From: Finlay Gardner <Finlay.Gardner@arun.gov.uk>
Sent: 06 March 2020 11:10
To: Planning.Responses <Planning.Responses@arun.gov.uk>
Subject: FW: LU/370/19/HH

From: chris barrow [REDACTED]
Sent: 06 March 2020 11:03
To: Finlay Gardner <Finlay.Gardner@arun.gov.uk>
Cc: Arun Windows & Supplies [REDACTED]
Subject: Re: LU/370/19/HH

On 5 Mar 2020, at 18:35, Finlay Gardner <Finlay.Gardner@arun.gov.uk> wrote:

Roof Detail Scale 1:100

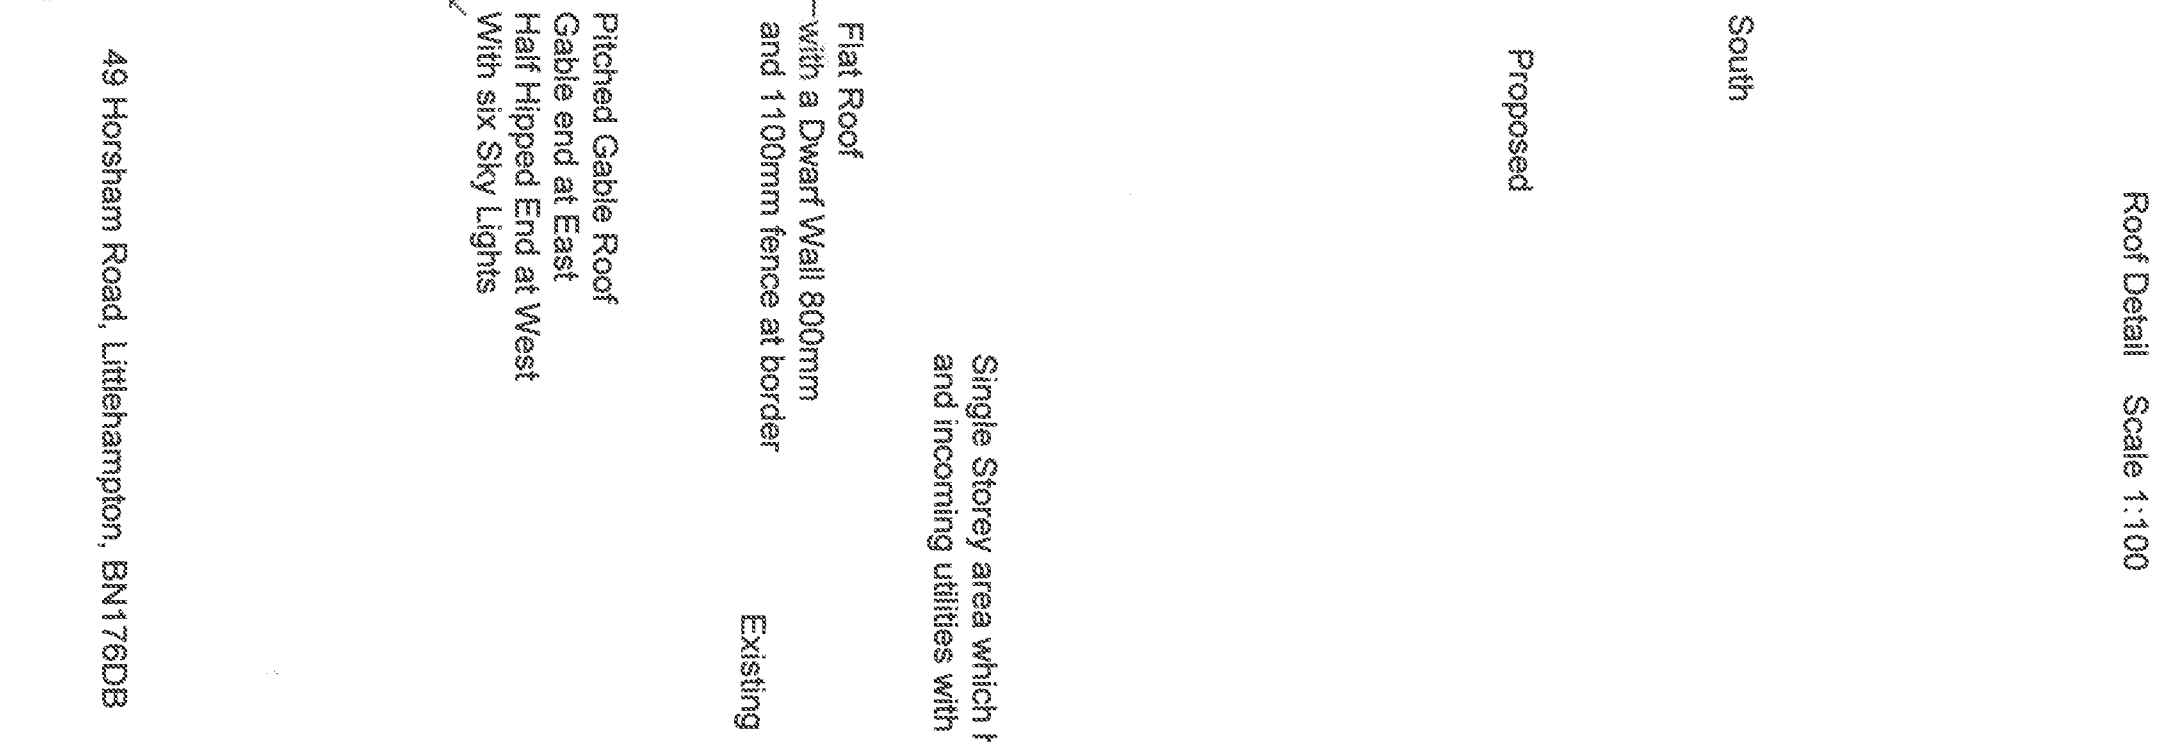
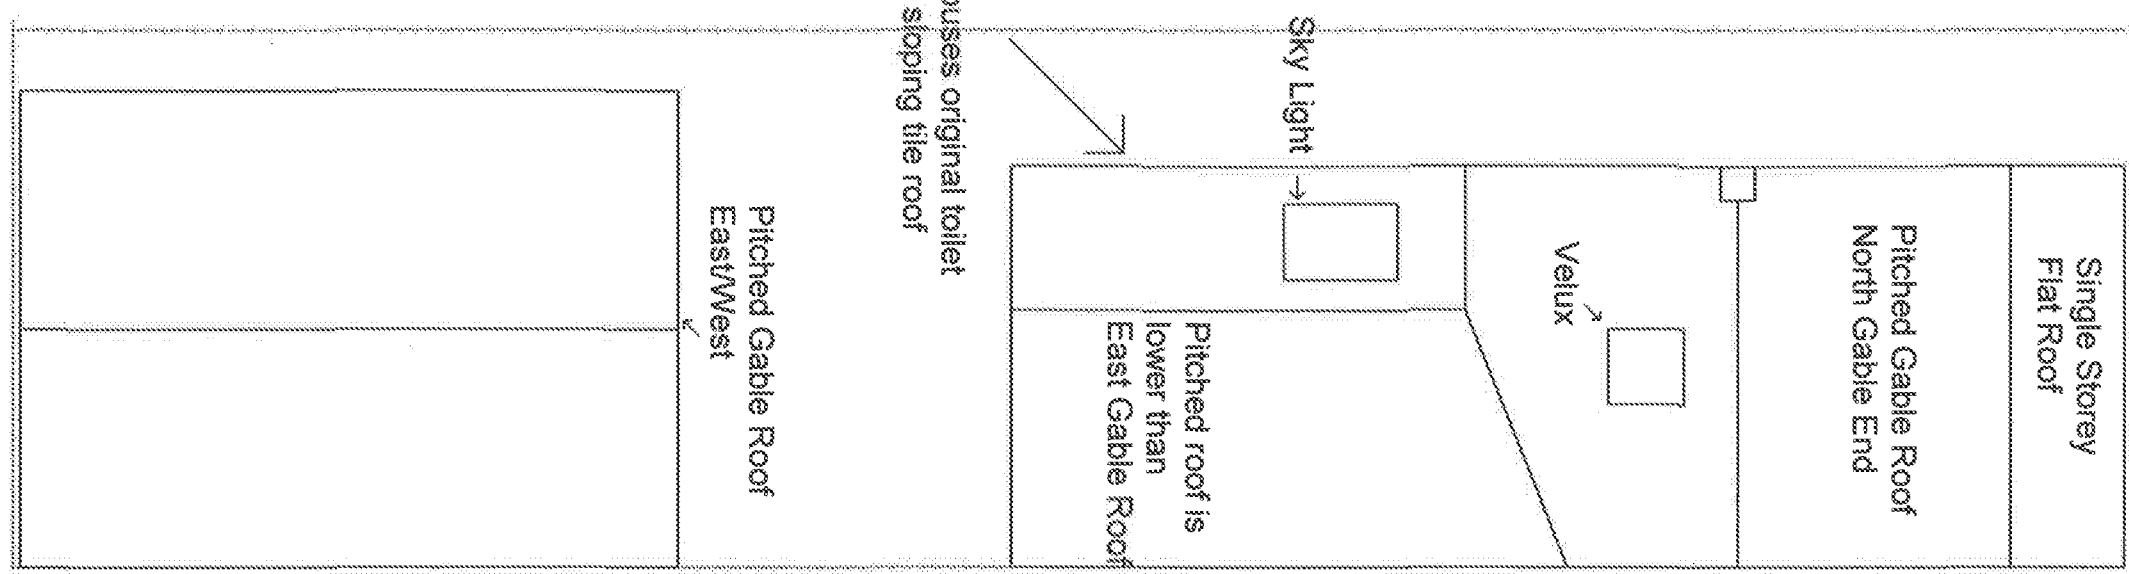
- The pitch roof needs to be shown above the shop/flat to be east/west as the gable ends are not to the front and rear currently.
- In the pitch there needs to have the existing roof light illustrated.
- The existing roof to the south needs to be shown to have a lower pitch height than that of the one visible from the street scene.
- The roof slopes need to be indicated.
